TR010064: Application by National Highways for the M60/M62/M66 Simister Island Interchange Project

The Examining Authority's Written Questions and requests for further information

Issued on 17 December 2024

Reproduced by permission of Ordnance Survey on behalf of HMSO ©
 Crown copyright and database right 2024. All rights reserved. Ordnance
 Survey Licence number 100030649.

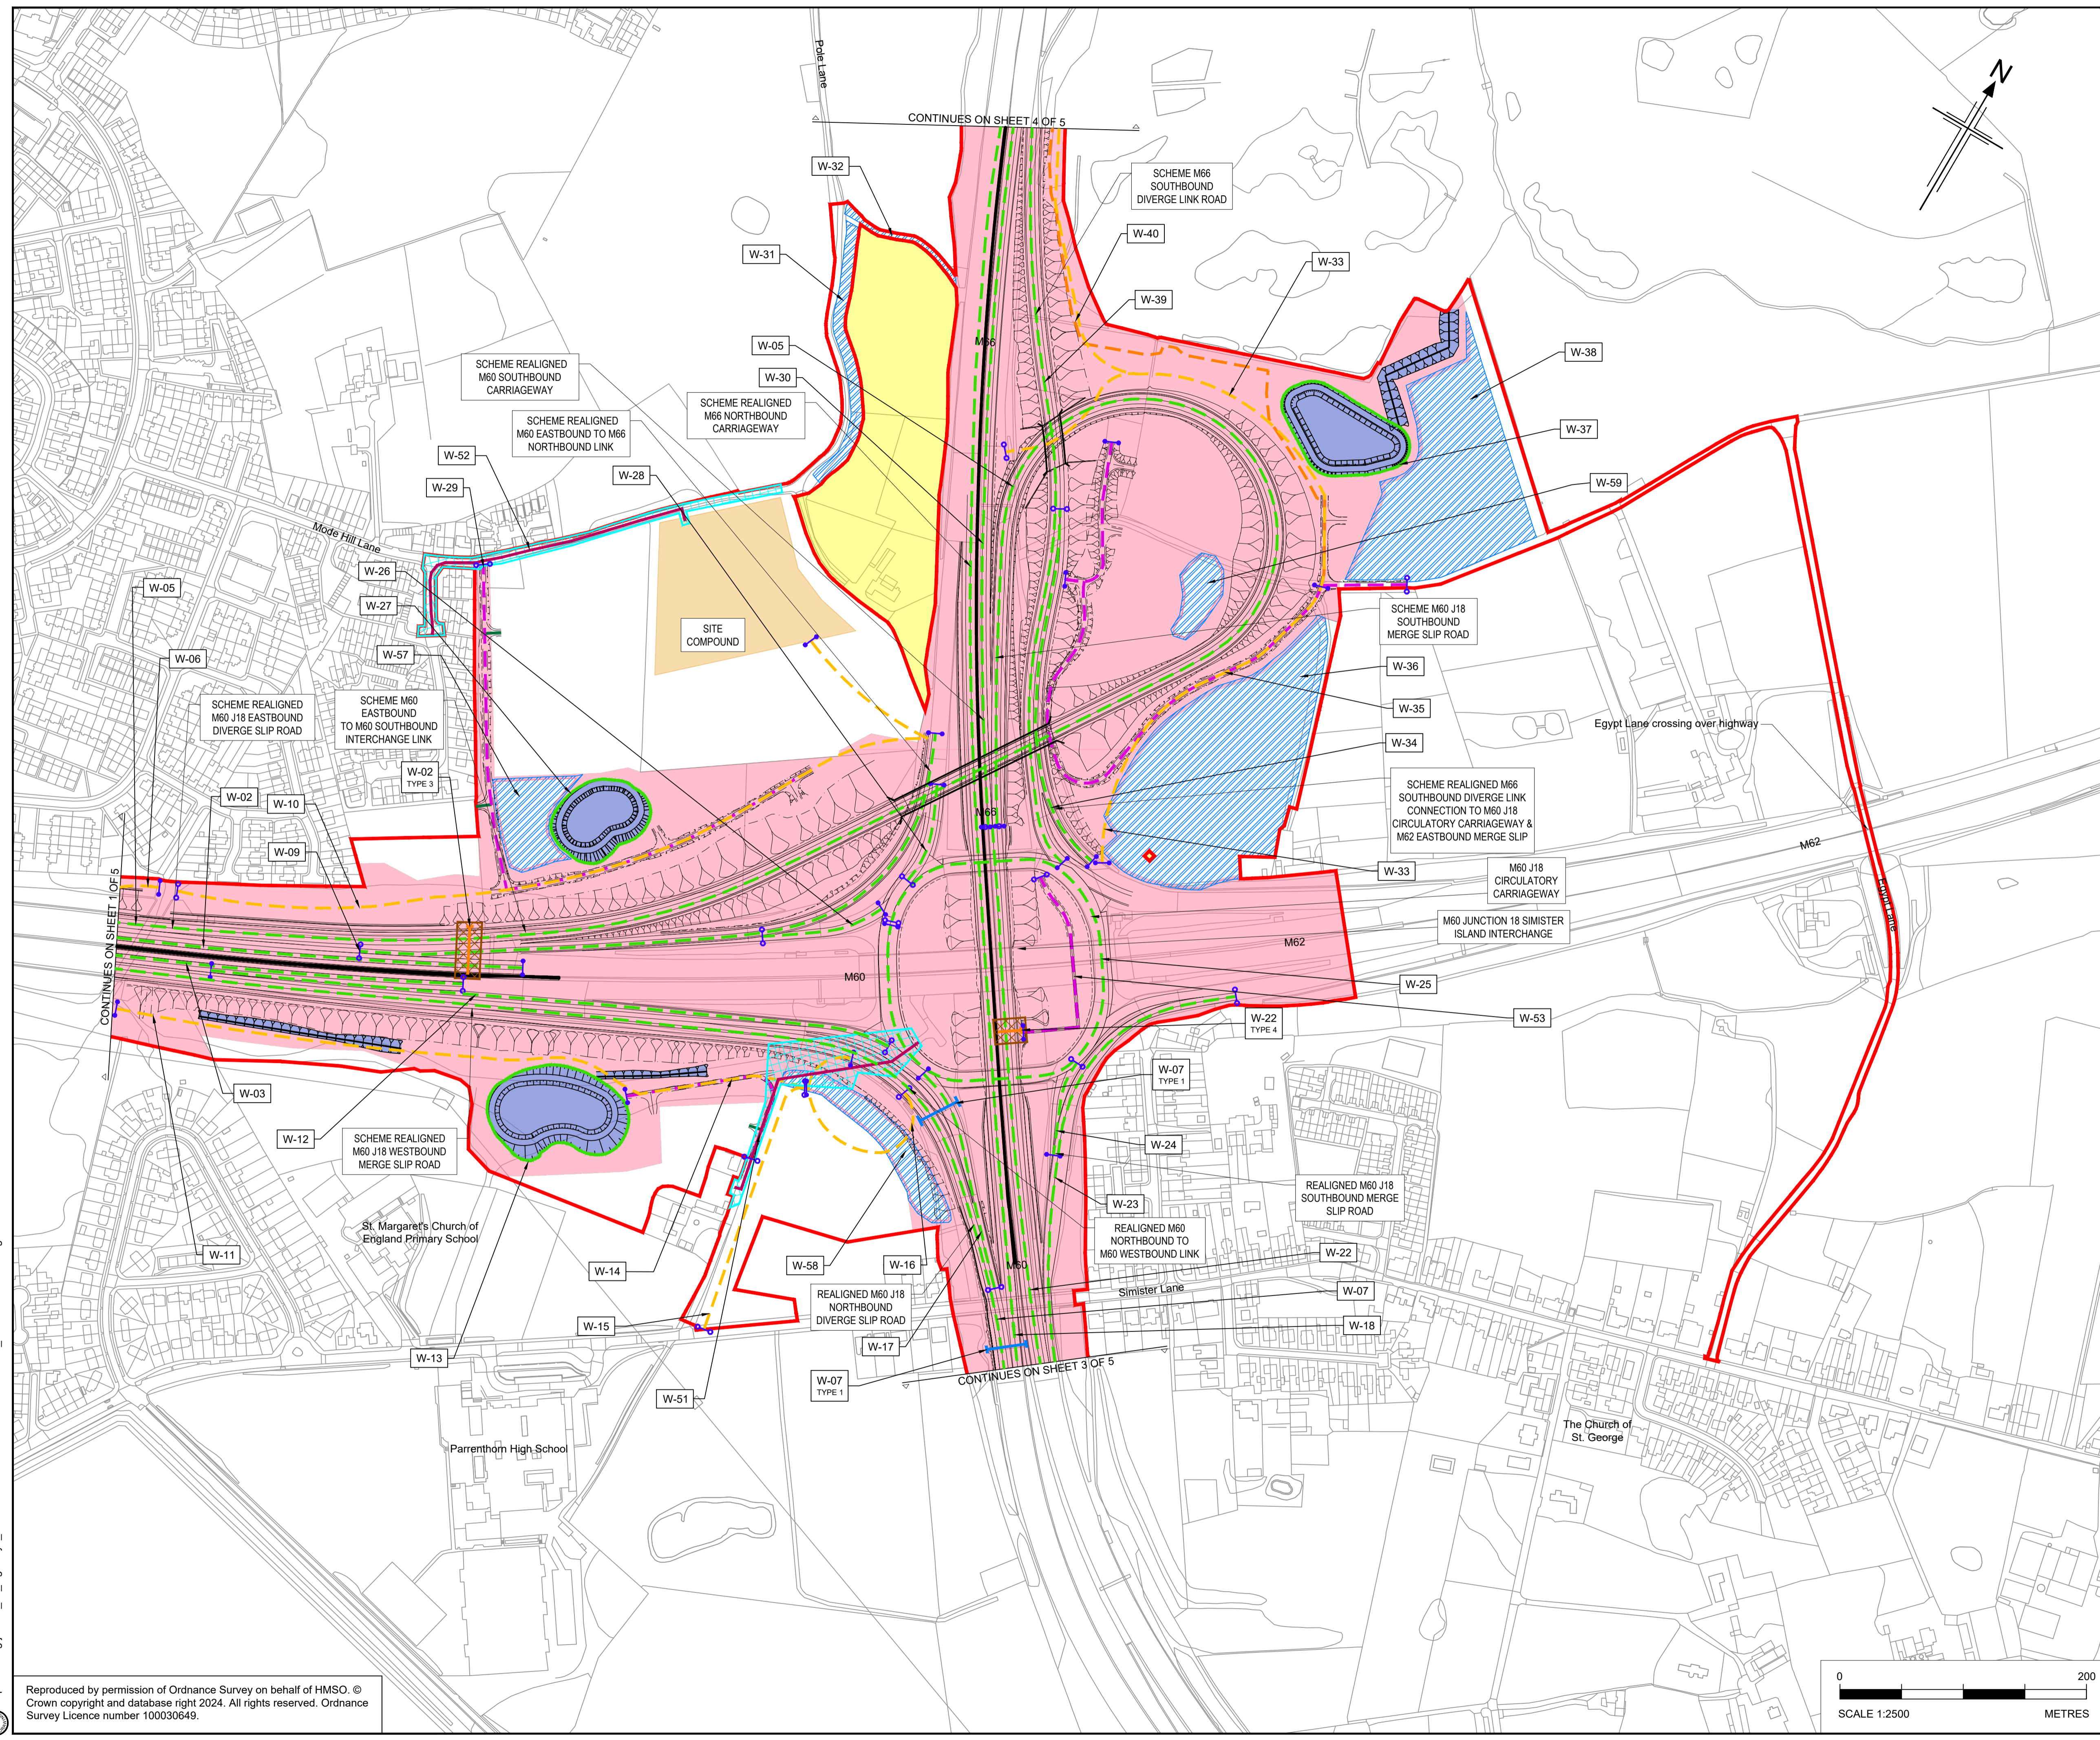
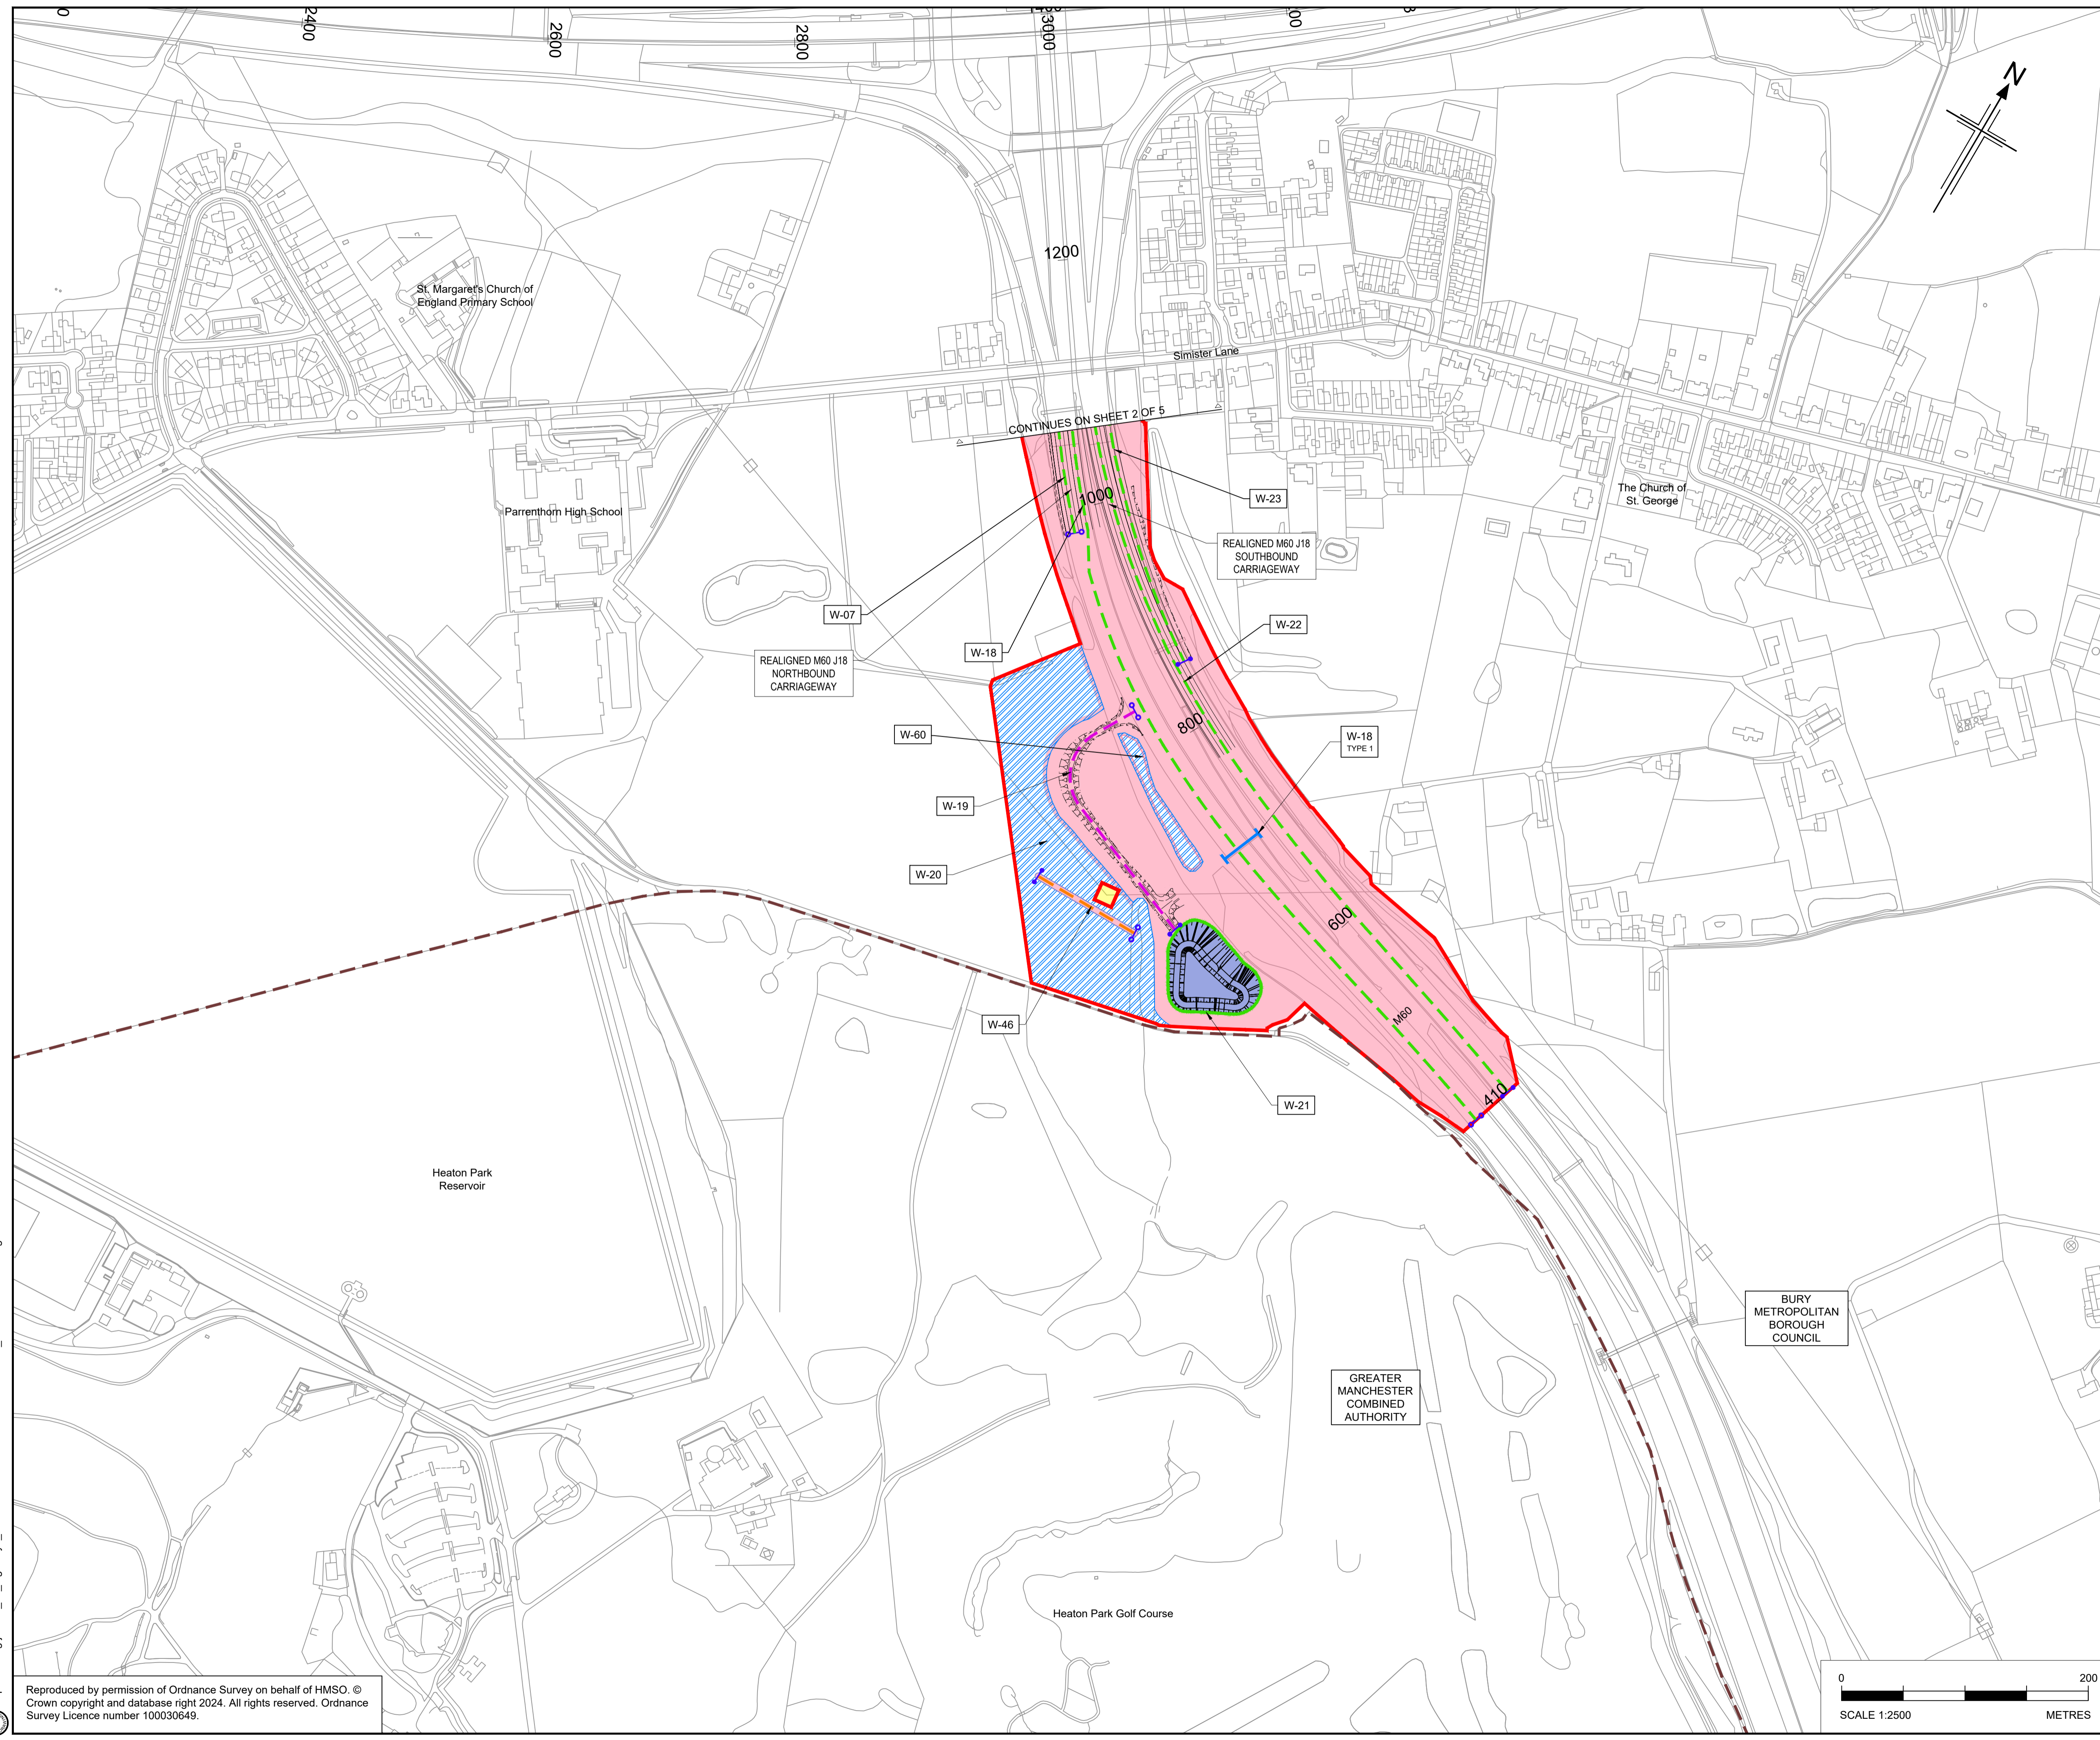
| CA.2.5 | Applicant | <p>Plot 1/1a</p> <p>In CAH1 the applicant explained that the whole of Plot 1/1a was within the ‘limits of highway deviation’ as indicated by pink shading on the Works Plans [AS-006]. The termination of the linear works (indicated by dumbbells) is shown on the Works Plans to be at the very eastern extent of Plot 1/1a. Explain why the entirety of Plot 1/1a is required for permanent acquisition, which includes carriageway beyond the termination of the linear works, and also land to the north and south of the M60 outside the existing slip roads and verge.</p> |
